Ref: SSD-98363228
S15235
12 August 2026

RE: SUBMISSION TO SSD-98363228, SENIORS HOUSING DEVELOPMENT
Address: 19-25 College Crescent and 9-15 Link Road, St Ives

ATTACHMENT 1

# Deep Soil

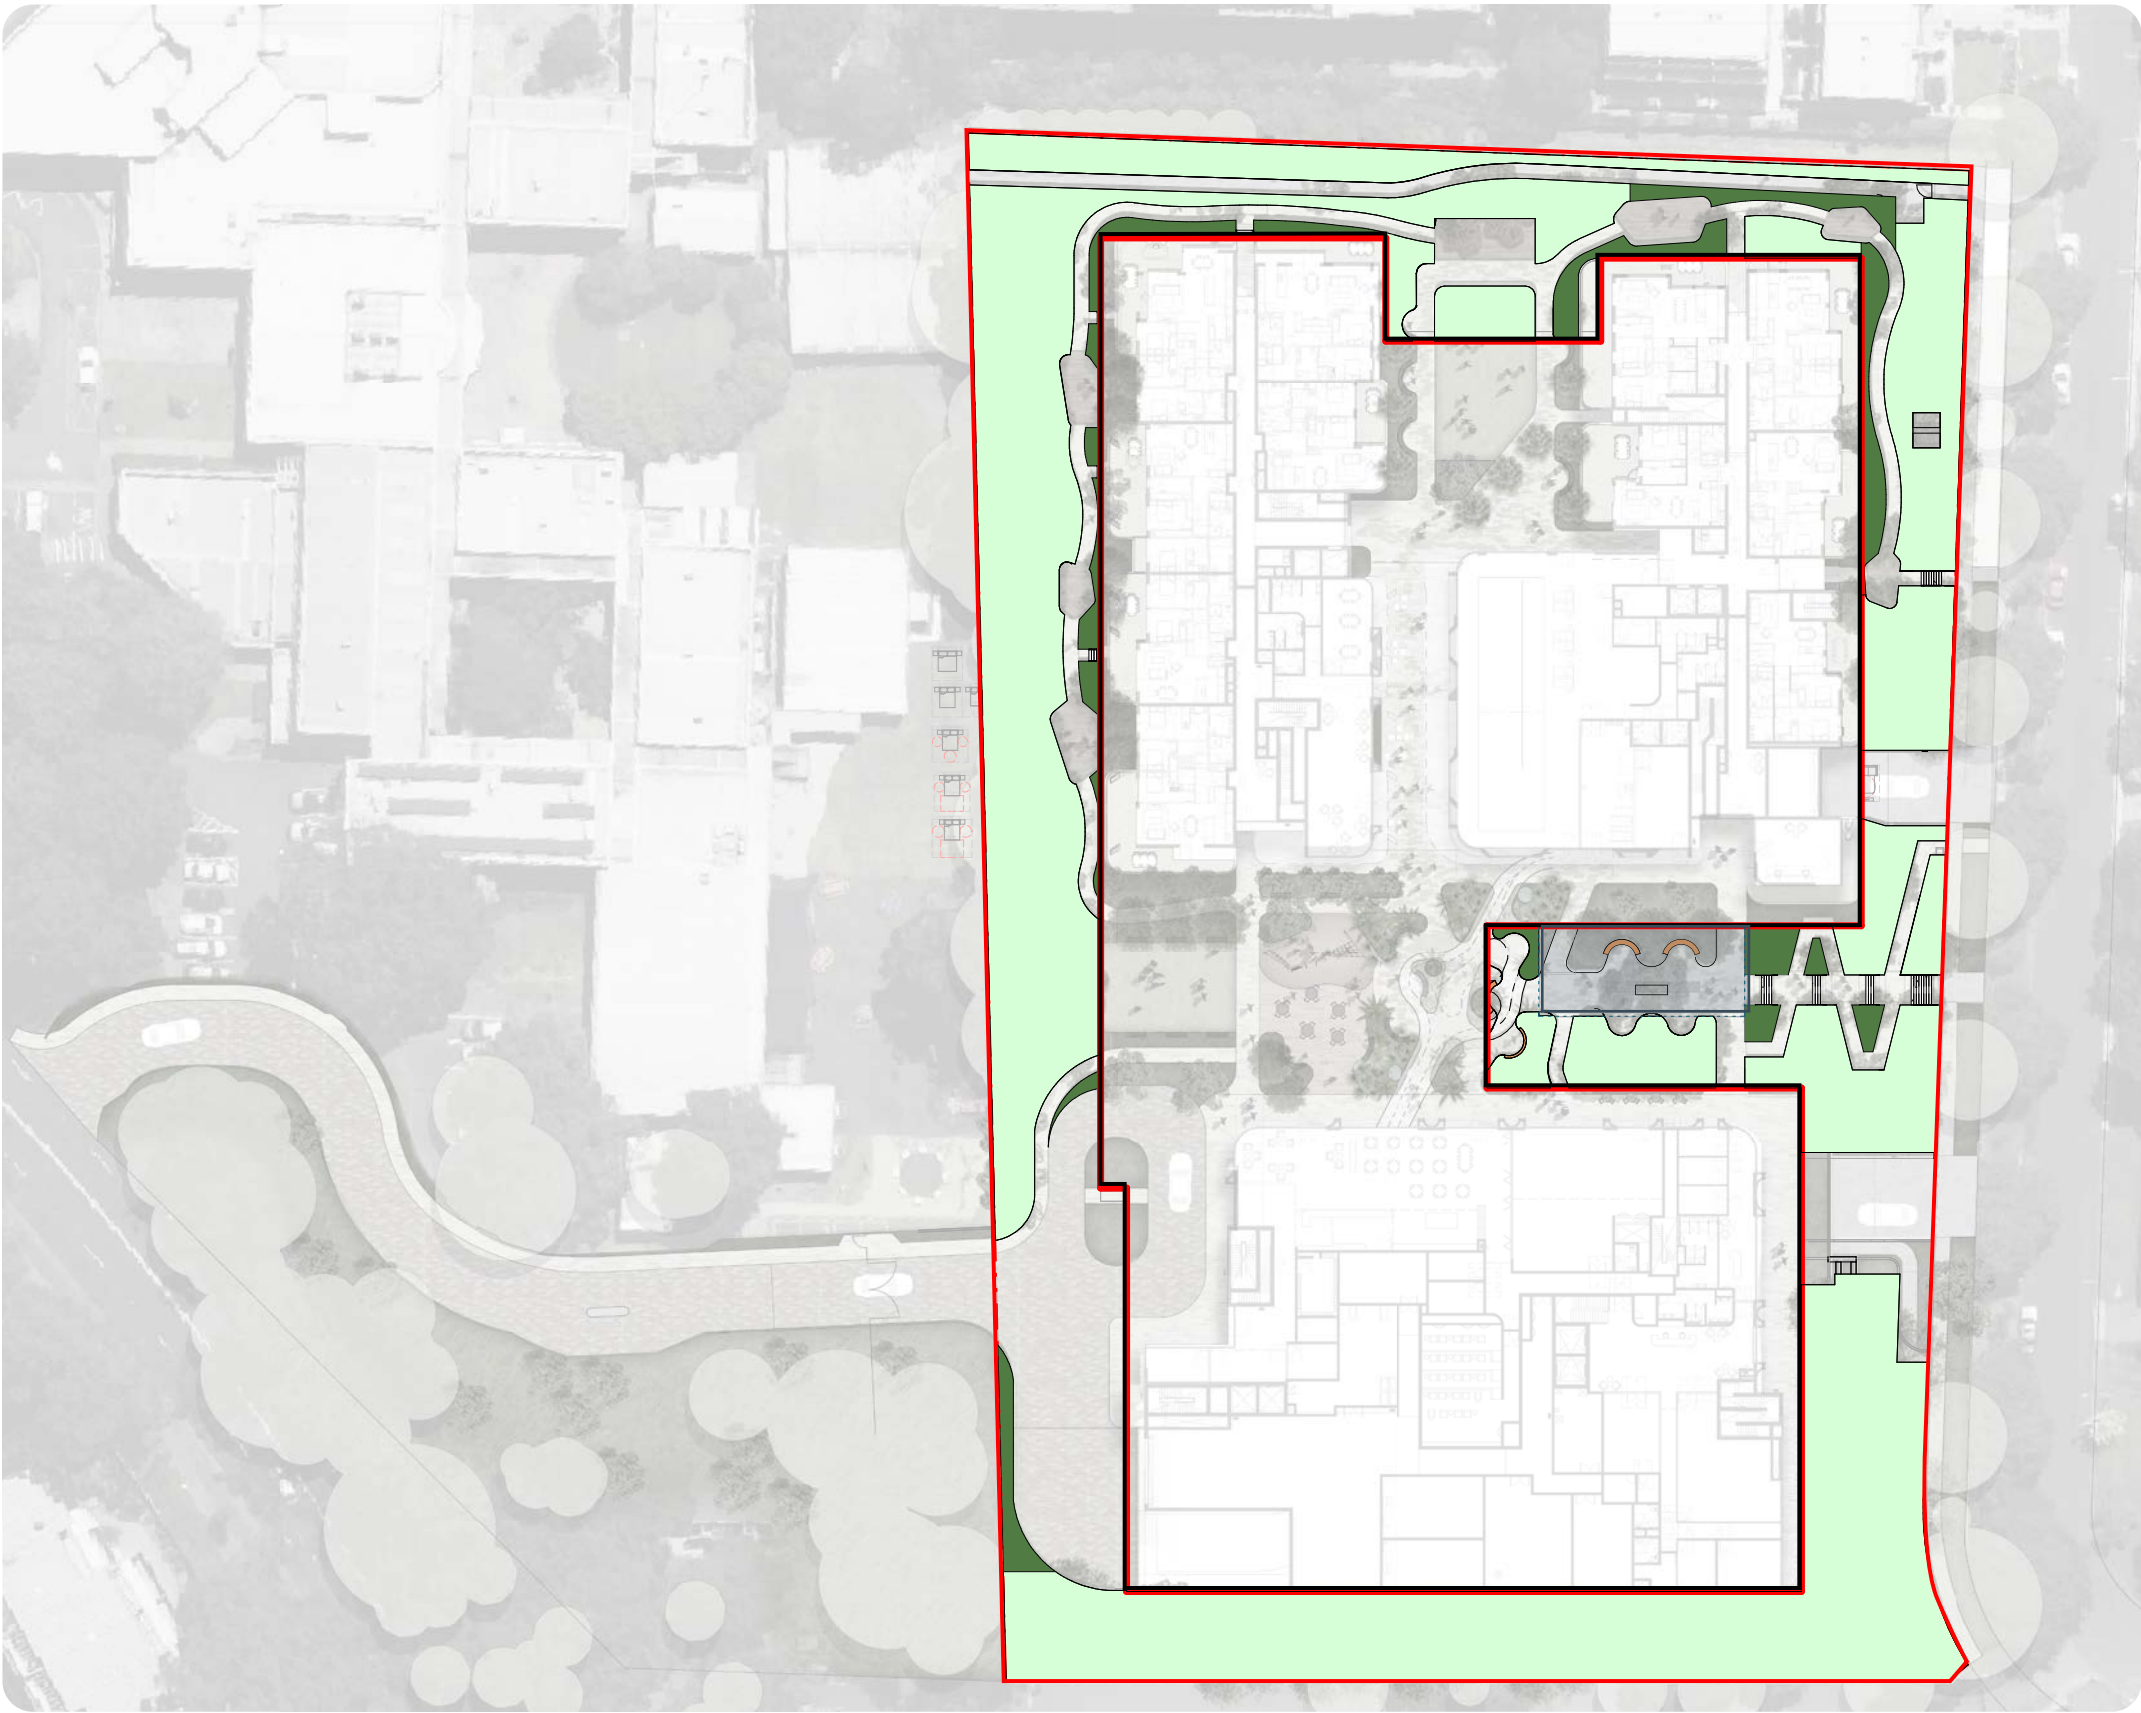
The proposed deep soil area is nominated as 3,435m² (24% of the site area) and has been incorrectly calculated as areas with dimensions of less than 3m and areas covered by structures have been included as deep soil and is inconsistent with the definition for deep soil area under the Housing SEPP.

Council has calculated the proposed deep soil area, as per the definition in the Housing SEPP, to be approximately 2,881m² (19.9%). The deep soil area calculations are required to be revised to ensure compliance with the definition for deep soil area and demonstrate compliance with Section 107 and 108 in Part 5 of the Housing SEPP.

In addition, Council identifies that the proposed deep soil for the site is inconsistent with the requirements for deep soil in Part 6.1 of the Greener Neighbourhood Guide (July 2026) which requires 25% deep soil to be provided, equating to an area of 3624.25m², or Part 7A.6 of the Ku-ring-gai Development Control Plan for a minimum deep soil area equating to 50% of the site (7248.5m²) with minimum dimensions of 2m.
